Development Control
Ribble Valley Borough Council

Your ref: 21.0731
Our ref: D3.21.0731
Date: 13th October 2023

Address: St James C of E Primary School Greenacre Street Clitheroe

Proposal: Redevelopment of the existing educational facility including part demolition of the existing infant school to provide a standalone nursery facility, together with the erection of a new infant block to the rear of the new nursery building, alongside additional car parking. Soft and hard landscaping treatment and vehicular and pedestrian access works off Greenacre Street.

Drawing file: planx_downloads / 21_0731_Amend_Proposed_Plan_18821.pdf

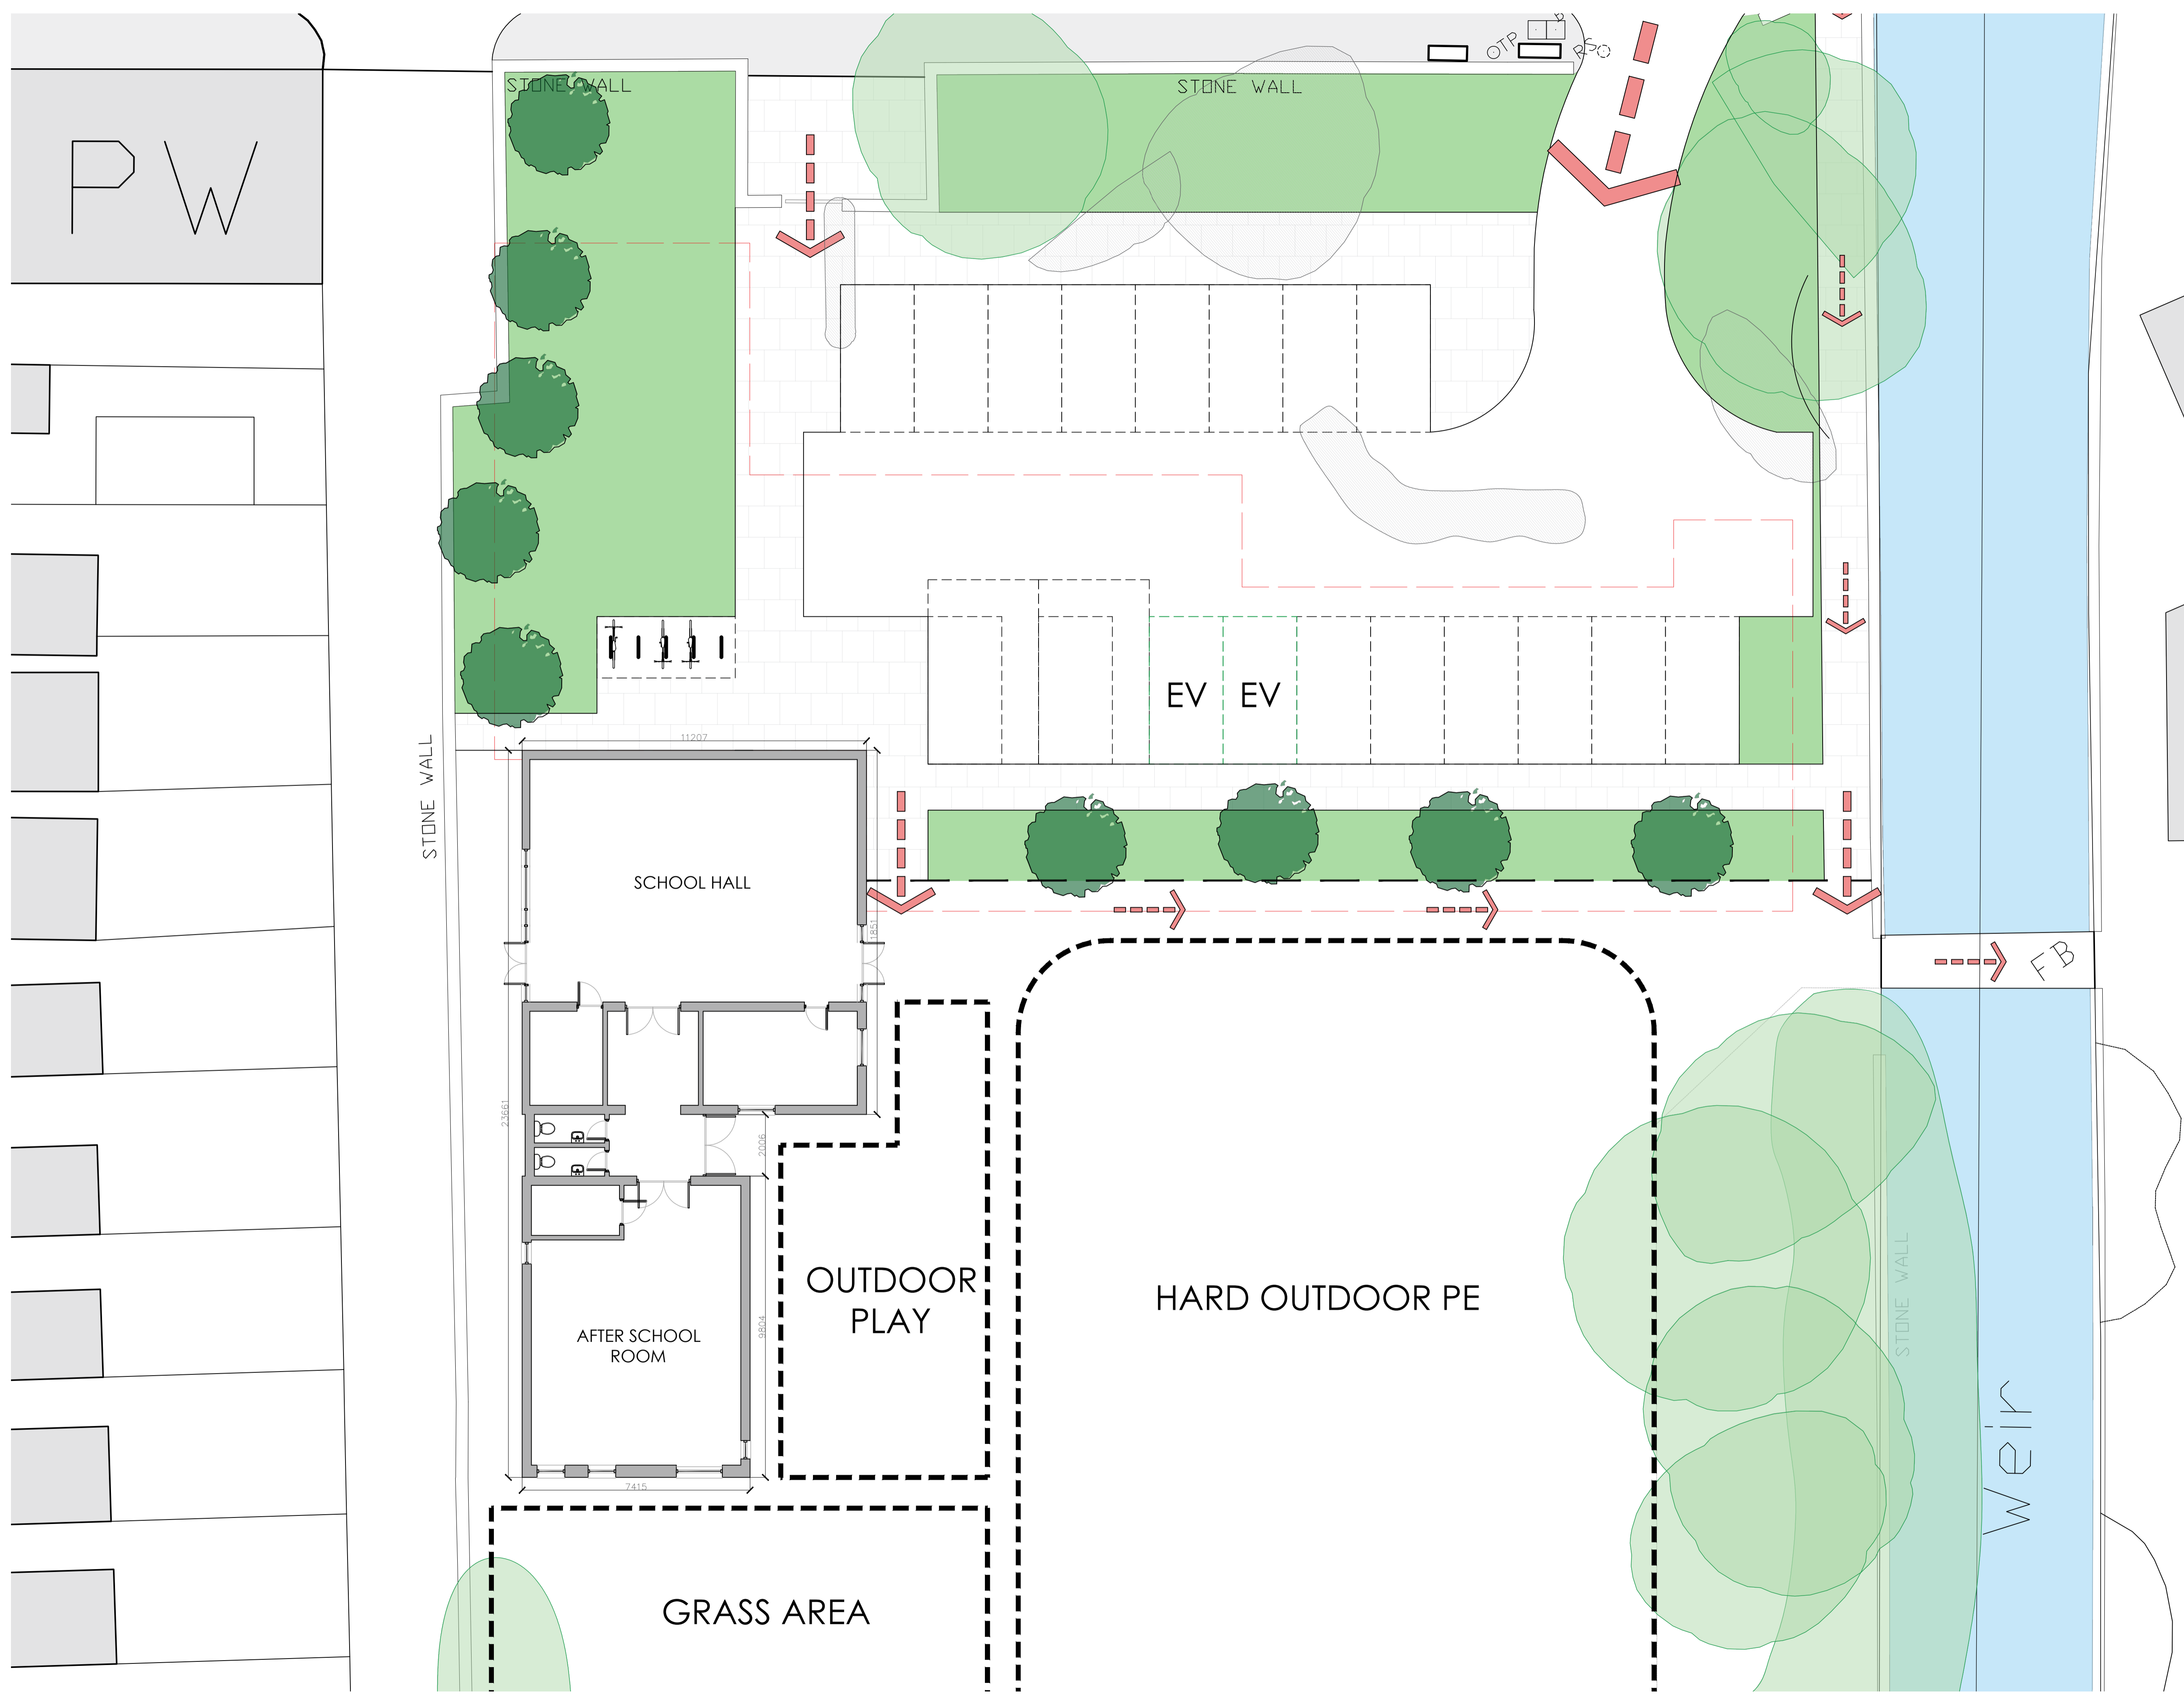
A new access will be created on Greenacre Street, approximately 27m west of the existing access to serve a new car park with 7 car parking spaces. The proposed access width is approximately 3.5m wide which has likely been designed at a narrow width to avoid the street furniture which includes a street lighting column, a one-way traffic sign, two broadband cabinets and a telegraph pole.

The proposed vehicle access will be of insufficient width to accommodate larger commercial vehicles such as the demolition and construction traffic, fire tender and goods delivery vehicles.

There is a small opportunity to widen the access between the existing street furniture however it is recommended that the new access is relocated north-westerly along Greenacre Street to ensure that a safe and suitable access is provided to the site for all vehicles which may require access to the site.

If the proposed access location is to remain then we would request that a swept path analysis is submitted to demonstrate that an emergency vehicle can access to site or that alternative agreed access arrangements are proposed. Regarding the construction vehicle access we would request a Construction Traffic Management Plan is submitted prior to commencement of development to address the concerns in this respect.

The car parks are to be paved in a tarmacadam material which is considered acceptable and a condition for a surface water drainage scheme is requested to ensure that no surface water is deposited onto the highway from the car park and vice versa.

Lancashire County Council acting as the Highway Authority would request further information to support the new access arrangements on Greenacre Street in particular to support large vehicle movements.
